# KITTITAS COUNTY

### MEMORANDUM

**TO:** All Staff  
**FROM:** Public Works Plan Review Team  
**DATE:** November 13, 2023  
**SUBJECT:** SP-23-00009 Sparks

**RE: SP-23-00009**

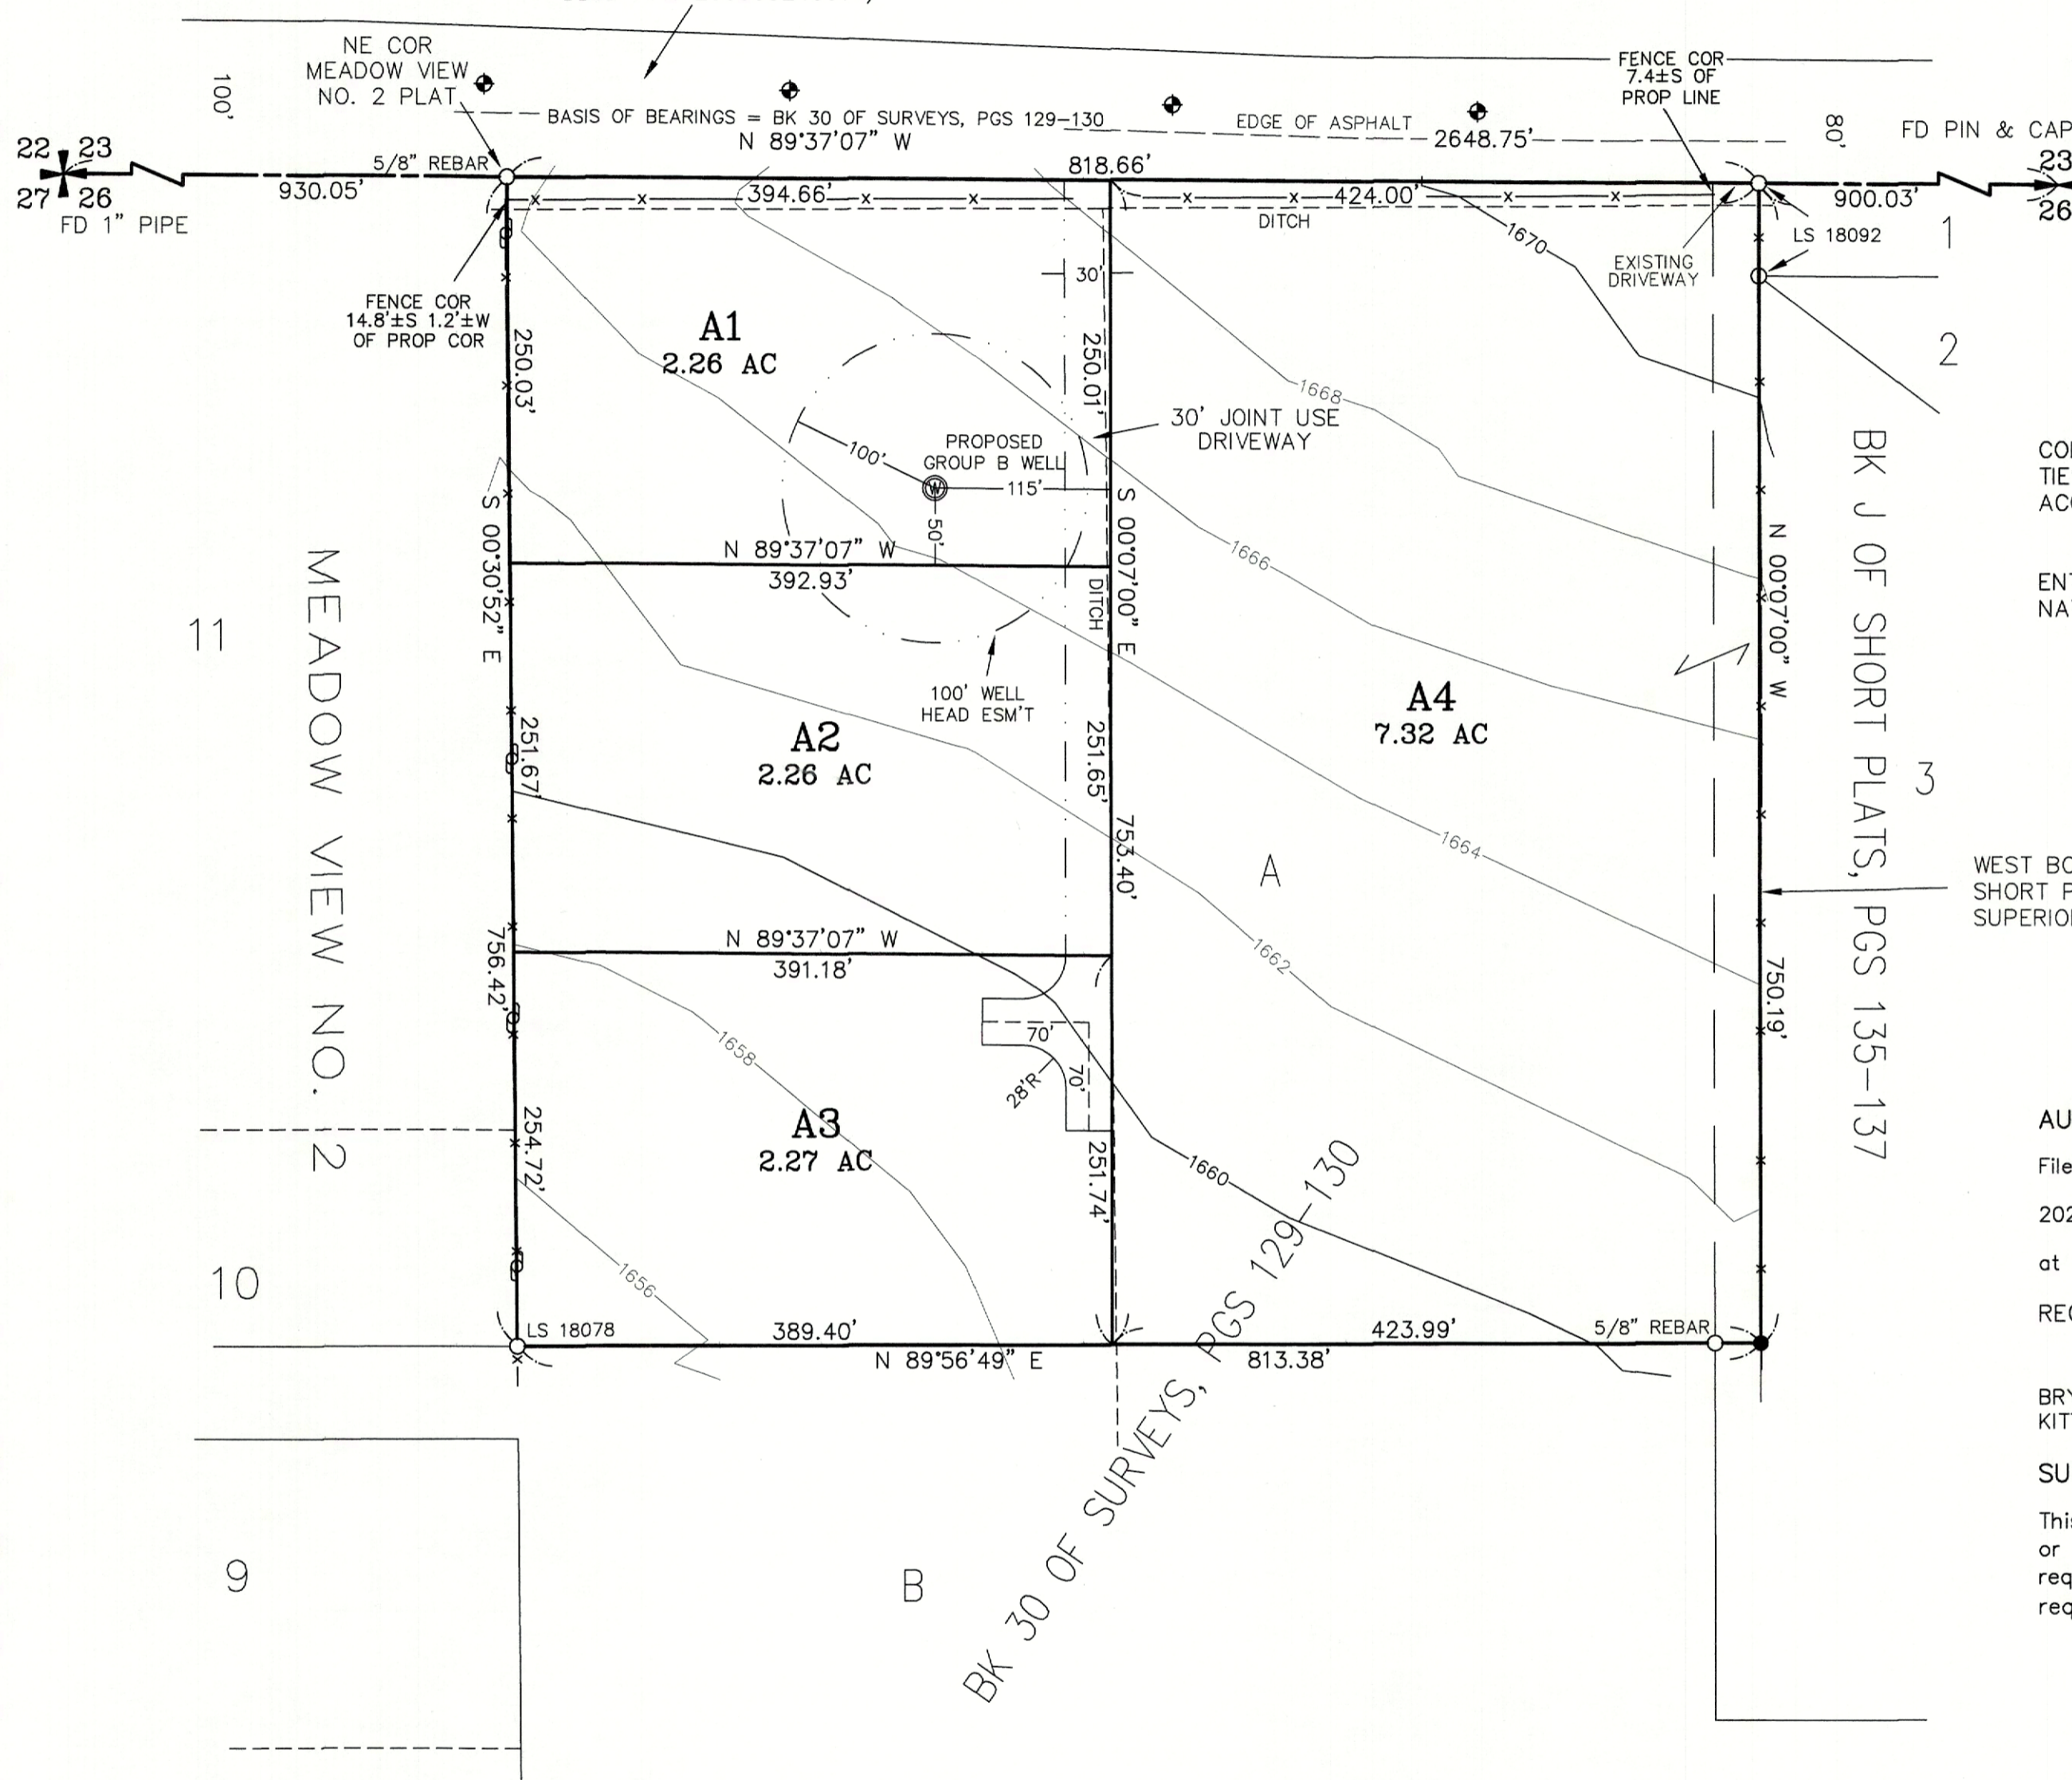
<b>SURVEY</b>	<p>The following survey comments will need to be addressed prior to final approval:</p> <ol style="list-style-type: none"> <li>1. Interior property corners will need to be set and shown on the final Short Plat.</li> <li>2. Please include language showing the 30' Joint Use driveway <u>Easement</u> as either existing, herein dedicated, or created by separate document.</li> <li>3. Please include suitable information for the accurate retracement of the 30' wide Joint Use Driveway Easement... particularly in the turnaround area.</li> </ol> <p>OF NOTE (no changes required)</p> <ol style="list-style-type: none"> <li>4. The "Found Encased Monuments" shown falling near the centerline of Bowers Road, would typically need to show bearing and distance ties in order to retrace their positions. It is presumed that these monuments are shown only as convenience, and are not part of any survey control network requiring retracement.</li> <li>5. Lot closures were not provided as part of the application. Given the simplistic nature of the lot layout, closure reports are not required. (JT)</li> </ol>
